Application No: LU/281/24/CLP

Site Address: 91 Wick Farm Road Littlehampton BN17 7HJ

Description of works: Lawful development certificate for the proposed use of an existing dwellinghouse as a children's home (C3B).

Proposed Plans

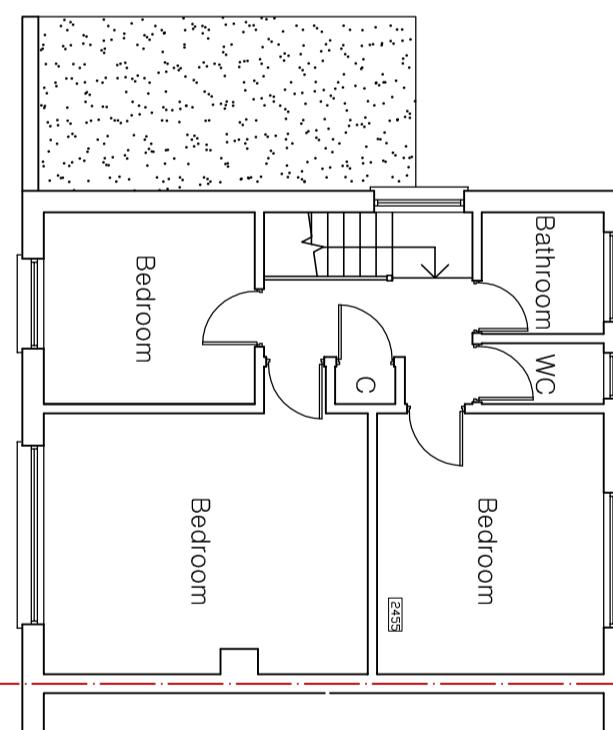
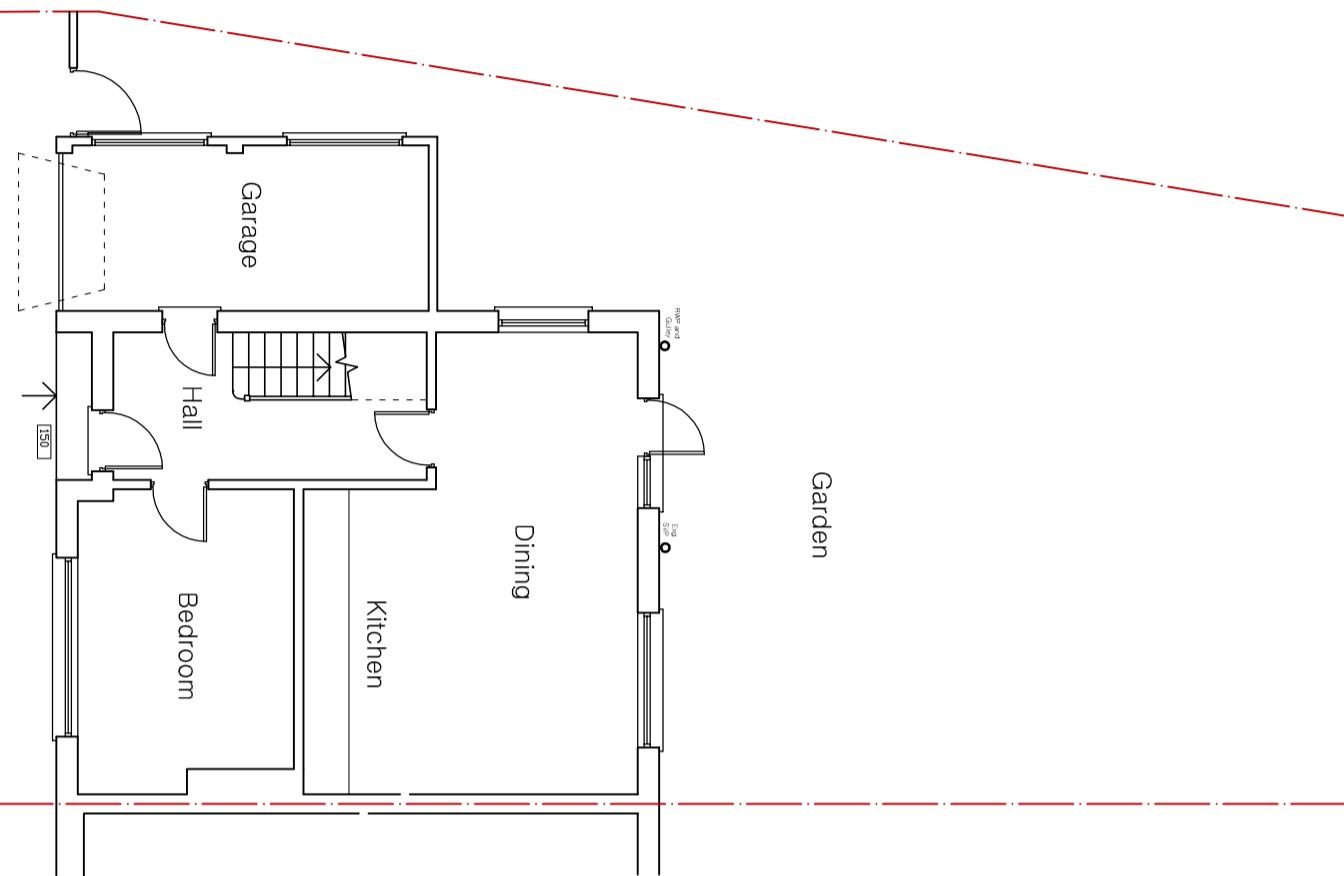
This application was considered by the Town Councils planning and transportation committee meeting held on Monday 2 December 2024. The committee had no objection to the application. Noting the intended use of the house, Members did however seek an assurance that the bathroom facilities were suitable.
